CITY OF ALBUQUERQUE

Re: 617 Madeira Drive NE
Traffic Circulation Layout
Architect's Stamp NONE PROVIDED (K18-D108)

Based upon the information provided in your submittal received 07-23-2020, the above referenced plan cannot be approved for Building Permit until the following comments are addressed:

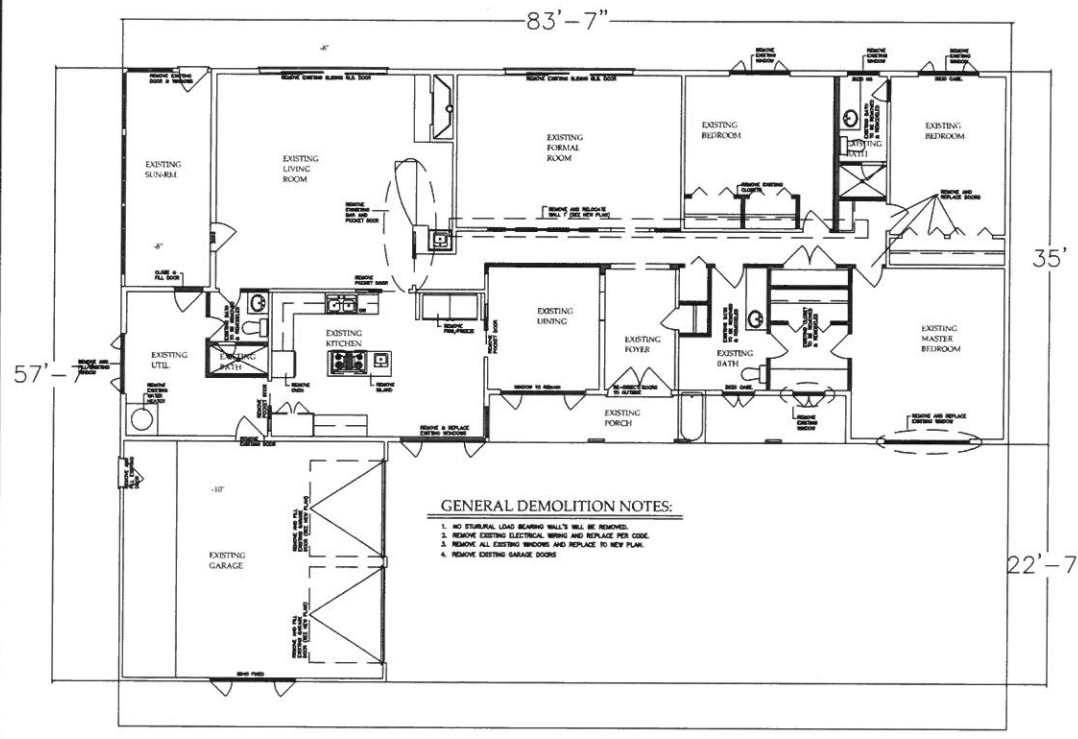
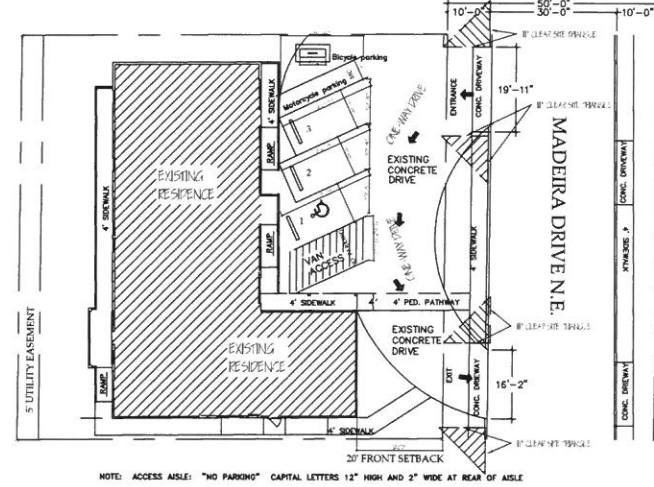
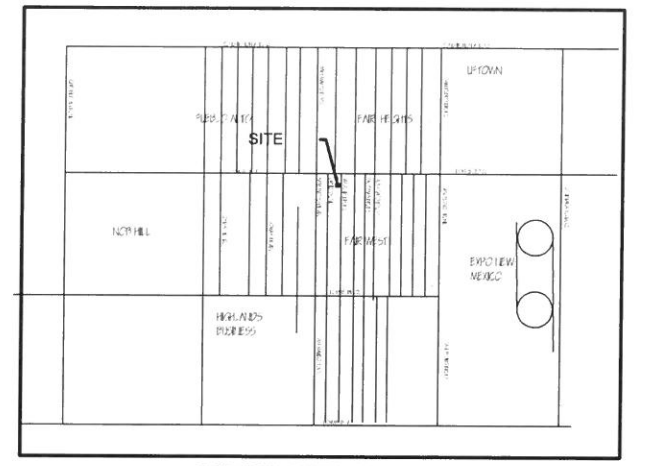
1. **The Traffic Circulation Layout must be stamped, signed, and dated by an Engineer or Architect licensed in the State of New Mexico.**
2. The proposed parking stall for angled (60 deg) and length are as follows: Stall length 22.9', width 9.8'.
3. The minimum parking stall dimensions are for 60 degree on parking:

Type of parking	Min. Width	Min. Length	Min. Overhang
Standard	9.8'	22.9'	2'
Motorcycle	4'	8'	N/A
ADA	9.8'	22.9	2'

****For diagonal (provide angle and dimensions based on the angle) parking stall dimensions please see DPM, Chapter 23, and provide the appropriate dimensions based on the requirements of the Development Process Manual (DPM).**

4. Motorcycle parking spaces shall be designated by its own conspicuously posted upright sign, either free-standing or wall mounted per the zoning code. Label pavement **MC**.
5. **A resubmittal fee of \$75 is required for this submittal only.** The next submittal just send it directly to me and no fees are required.
6. Please clean up site plan sheet adjacent to SCOPE OF WORK TITLE.
